PROJECT NO. PR-2022-007875
Application No. SI-2022-02109-SITE PLAN

SUBMITTAL DESCRIPTION: Revised Site Plan, Landscape Plan Infrastructure List and Deviation Justification

Memorandum

Project: Kimmick & Rosa Parks

**REAR ELEVATION**  
SCALE: 1/4" = 1'-0"

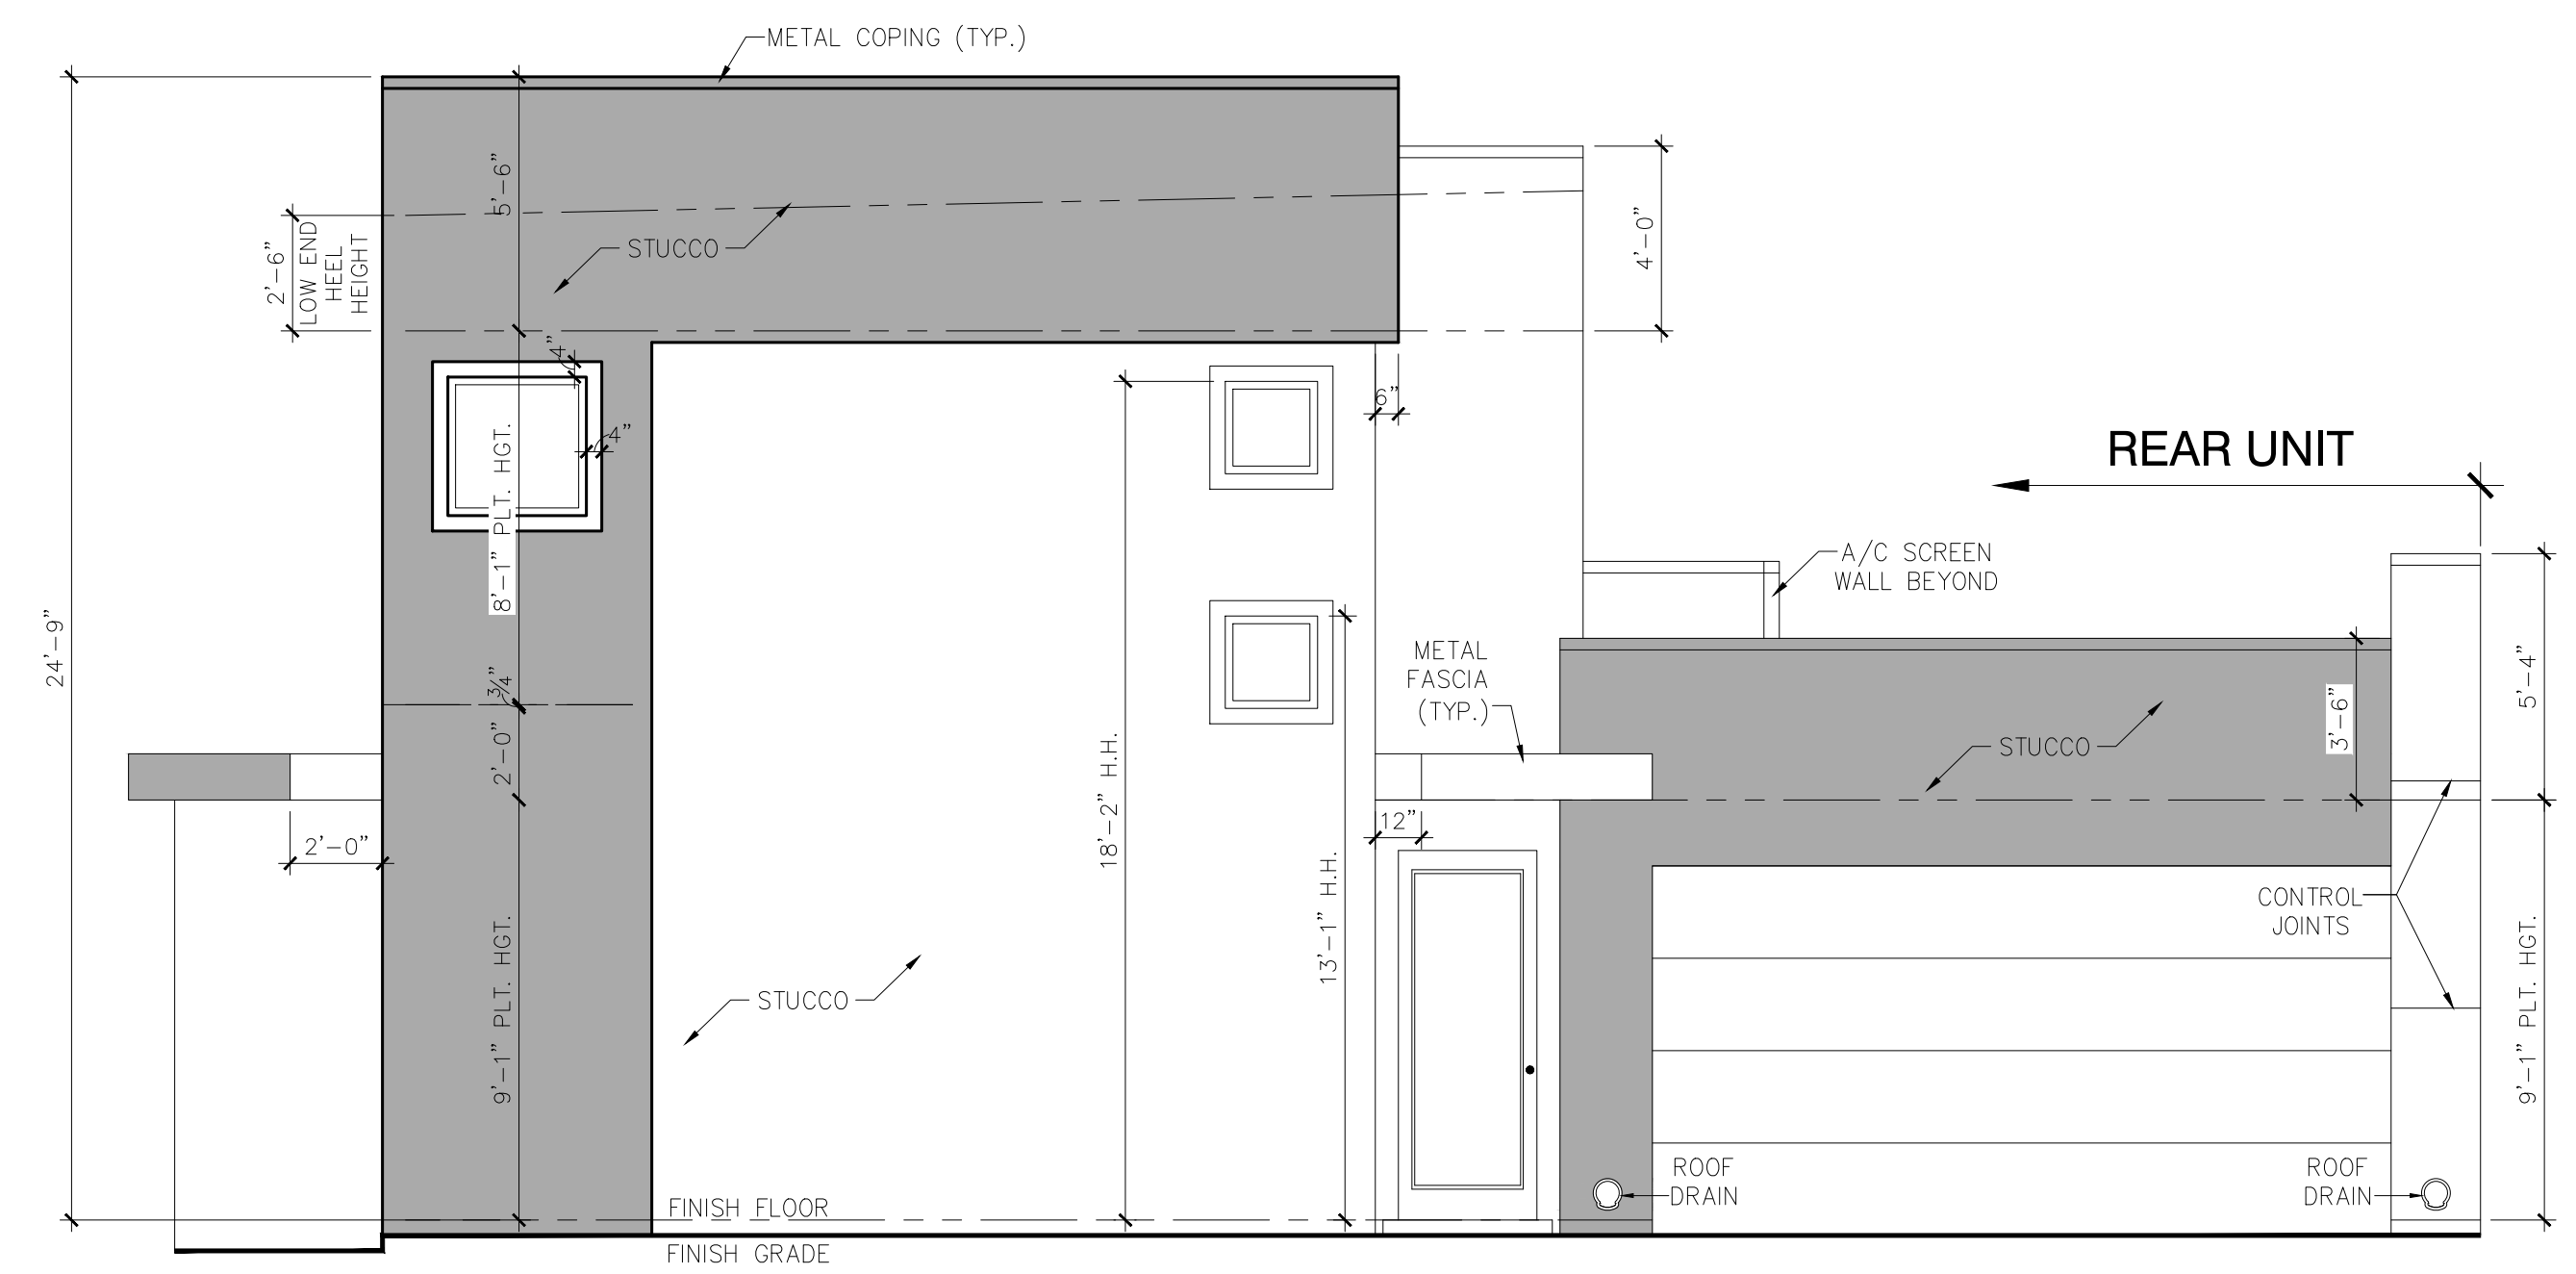
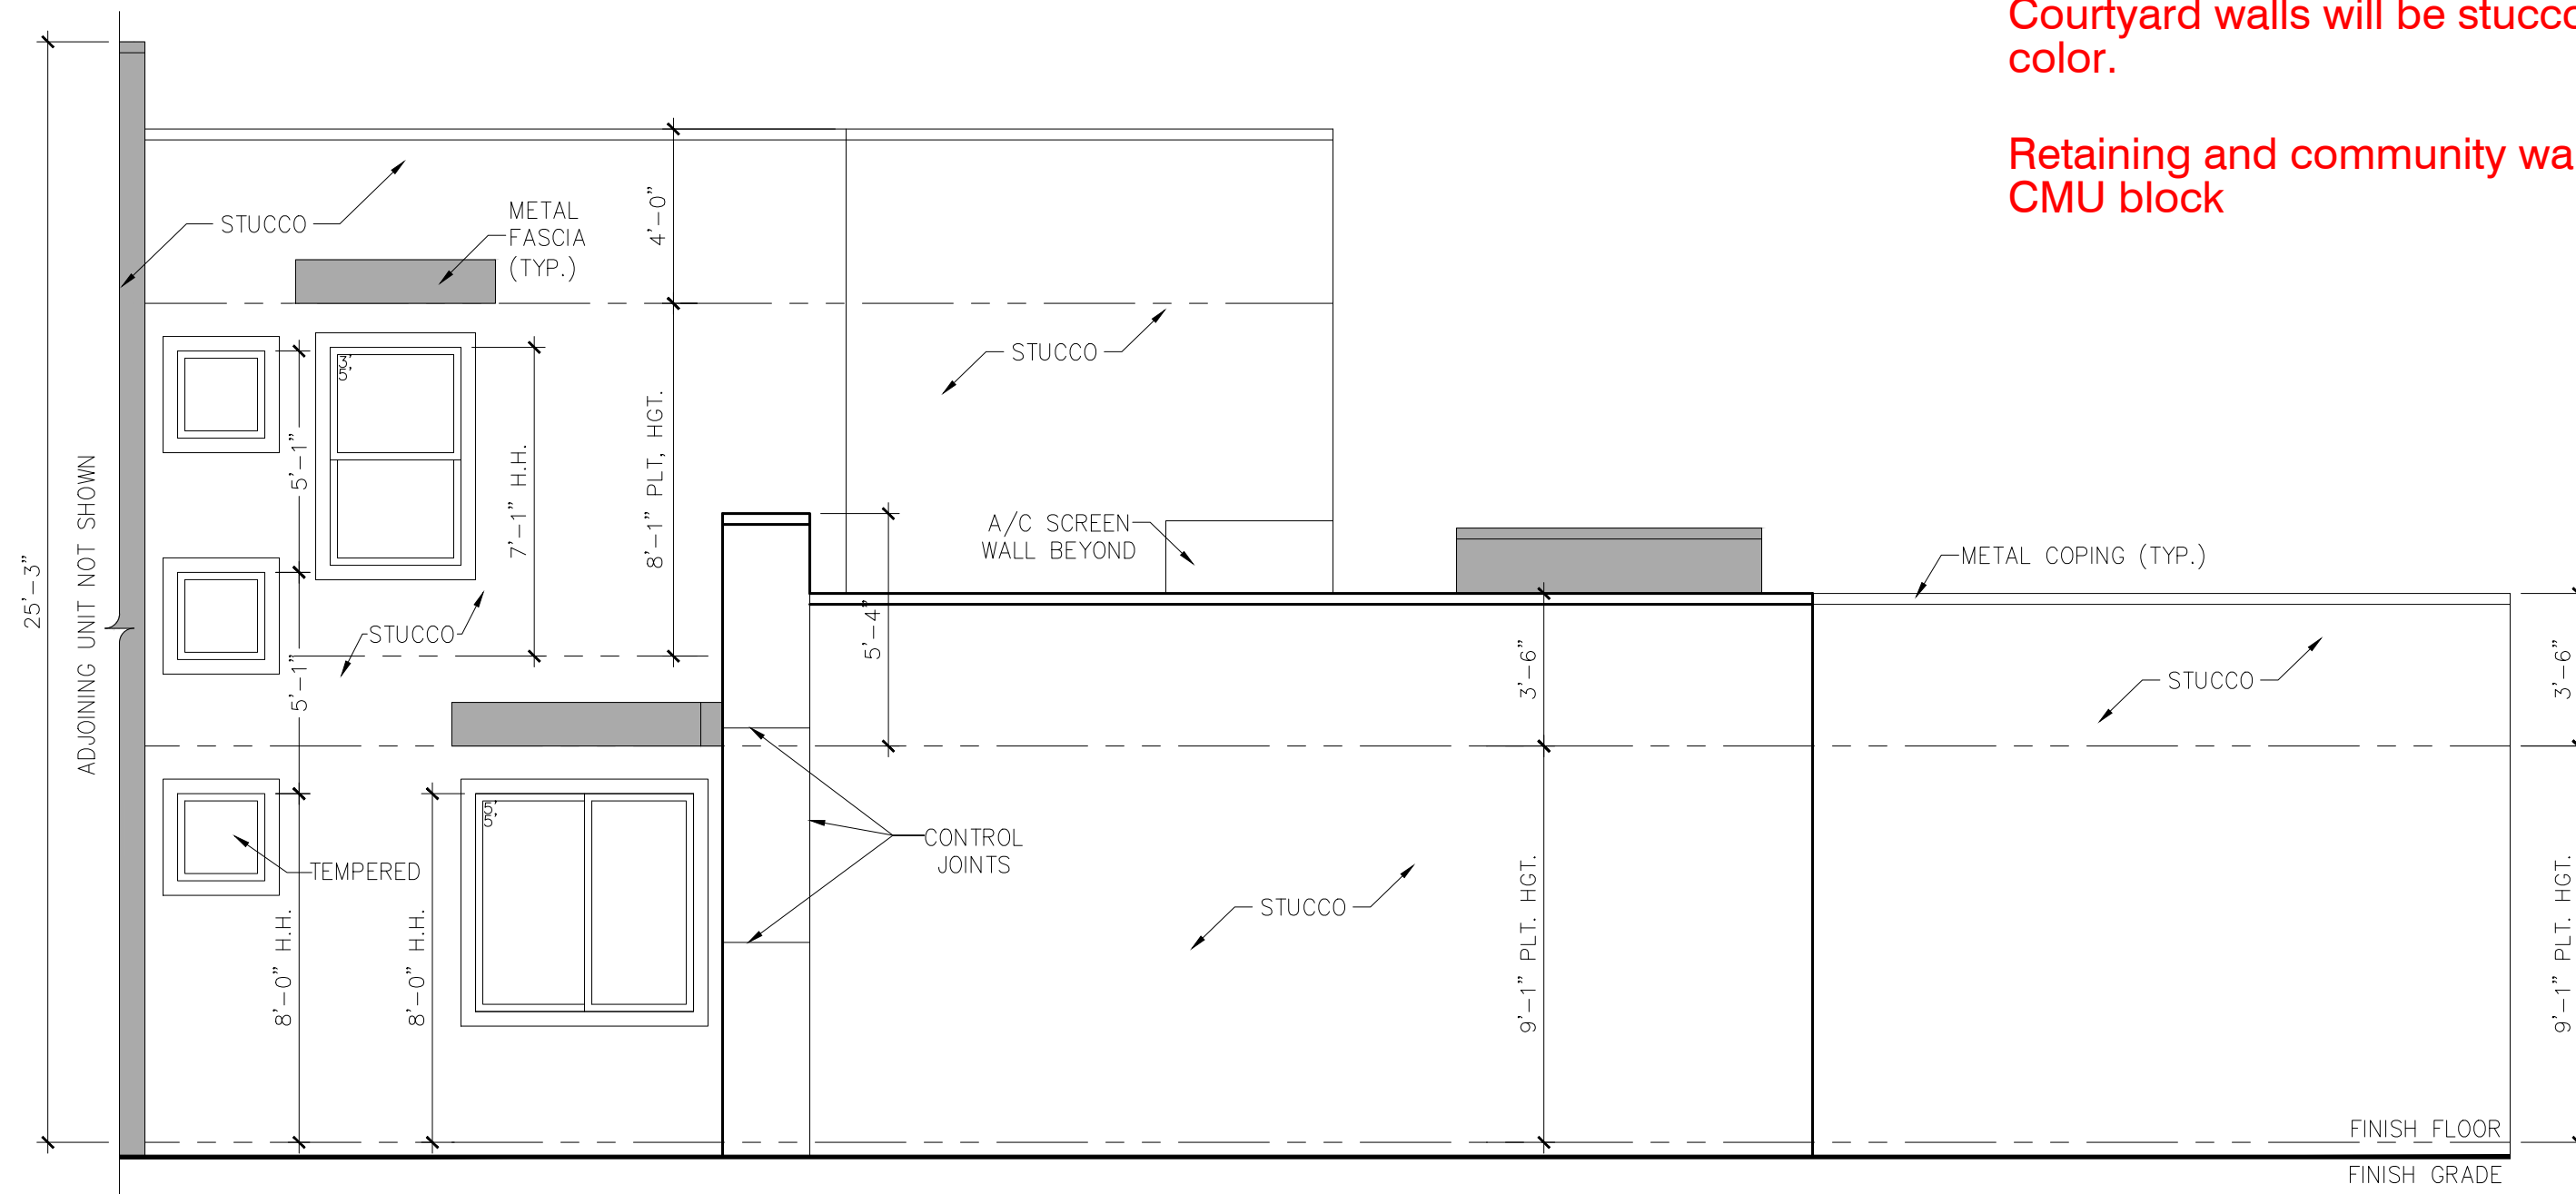
- 1. Limit the colors of exterior surfaces of structures, including but not limited to mechanical devices, roof vents, and screening materials, to those with light reflective value (LRV) rating between 20 percent and 50 percent.*
- 2. Colors shall blend with the surrounding natural environment and generally include yellow ochres, browns, dull reds, and grey greens.*
- 3. Trim materials on façades constituting less than 20 percent of the façade's opaque surface may be any color.*

- 1. Design consideration has been made to ensure compliance of 5-2(J)1(d). All buildings will have exterior stucco color of Canvas with River Rock colored stucco*

and trim accents. Courtyard walls are contemplated to also be stucco and colored to match the building exterior. Please see colored renderings which are included with this site plan submission. The LRV for Canvas is 44.0 while the LRV for River Rock is 31.1.

2. Design consideration was made to ensure color palates which are in harmony with the surrounding high desert landscape. Please see colored renderings which are provided as part of this site plan submission.
